Application by Able Humber Ports Limited for an Order granting Development Consent for the Able Marine Energy Park

The Applicant's Response to the Department of Transport's 'Minded to Approve' letter in respect of Compensatory Measures, 15 October 2013

Able Marine Energy Park – compensation measures

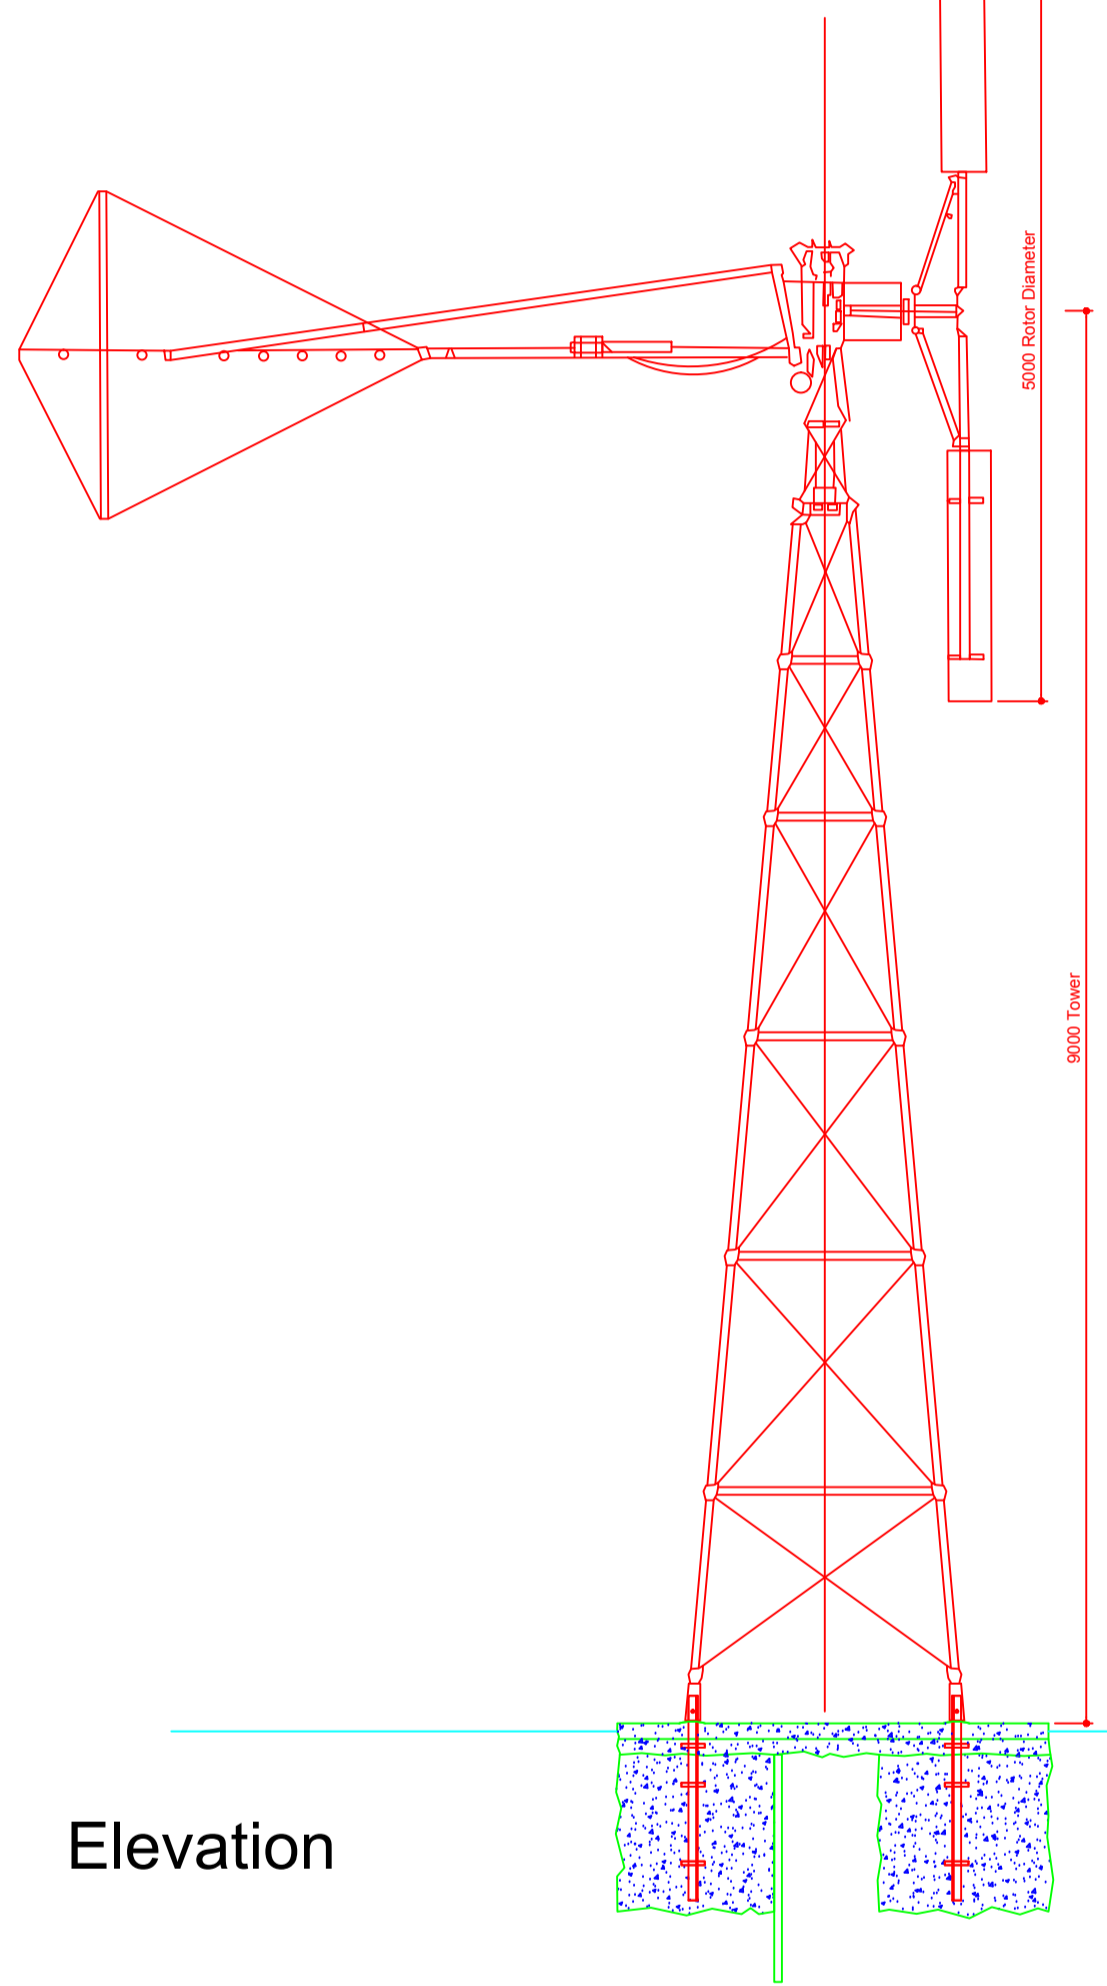
- iii) Further information on the frequency of wind speeds as recorded at a Met Office station located at Donna Nook, has been presented by Able UK to support their view that the use of wind pumps will be an effective mechanism for moving water around the compensation site. These records are for a site some distance from Cherry

Cobb Sands and may not be representative of wind speeds and their frequency at the compensation site. Nevertheless we suggest this issue can be resolved relatively easily by consideration of alternative means of moving water round the site, such as the use of motorized pumps, as back-up to cover any failure in the effectiveness of the wind pumps. We advise that a commitment to this effect in the CEMMP would increase confidence in these proposals.
